**REQUEST**

Current Zoning: N1-A (neighborhood 1-A)  
Proposed Zoning: N1-E(CD) (neighborhood 1-E, conditional)

Approximately 1.988 acres located at the deadend of Pickway Drive, west of North Graham Street.

Staff recommends approval of this petition upon resolution of outstanding issues related to site and building design.

C200

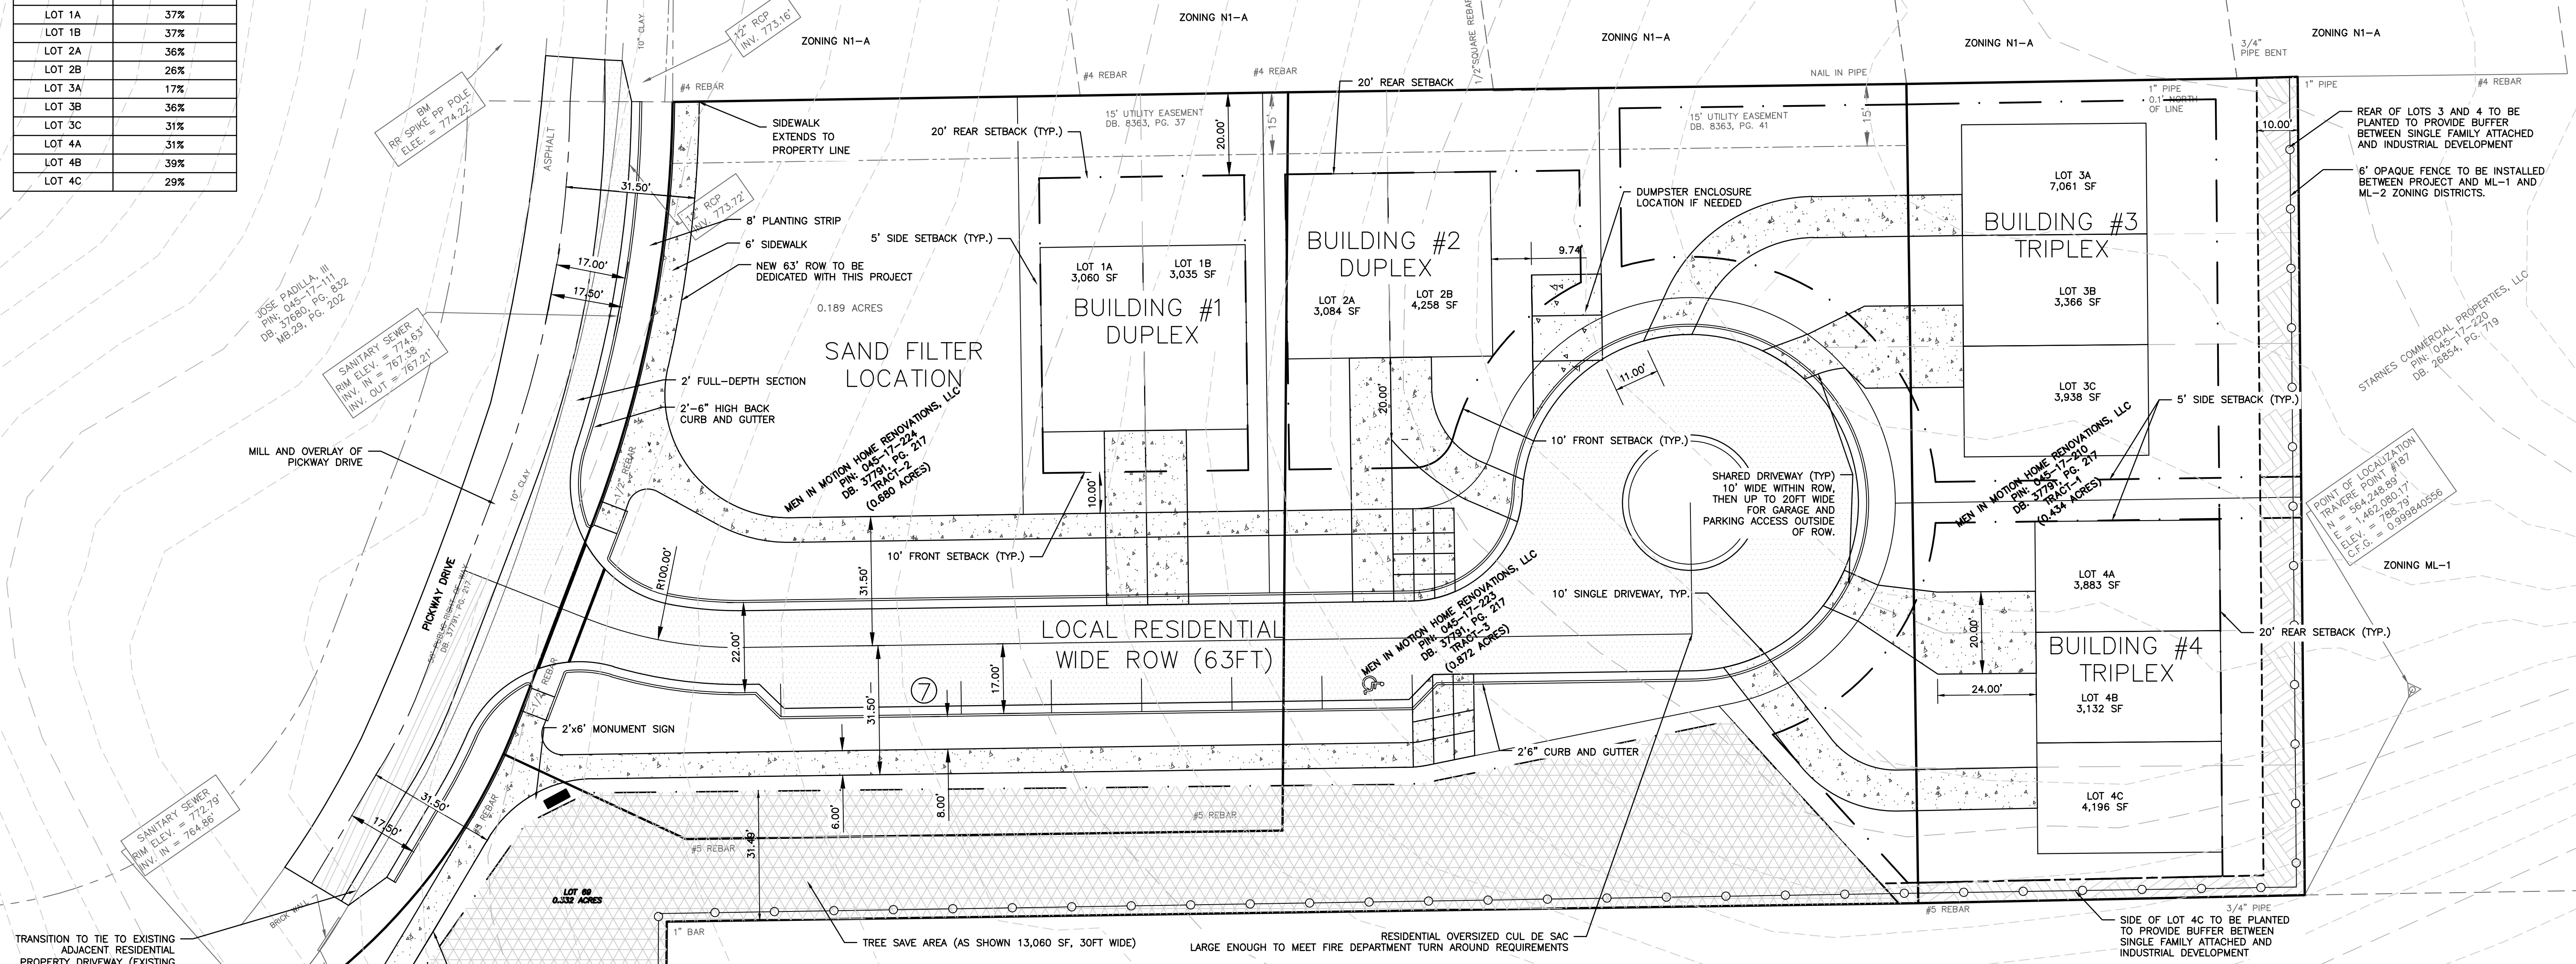
4. Specify **in the conditional notes what type of planting standards will be provided** in the rear setback against PID 04517220 **and along the side of lot 4C**. Consider adding conditional notes for planting standards that mirror the standards outlined for Class B or Class C Landscape Yards. ~~Add a 6' opaque wooden fence along the site's boundary against PID 04517220.~~

6. Modify the driveways shown for the triplex buildings to be compliant with Article 19.6.A.1.a.

8. Clearly distinguish and label each building as being on its own lot. Sublots for the individual units should be distinguished by dashed lines.
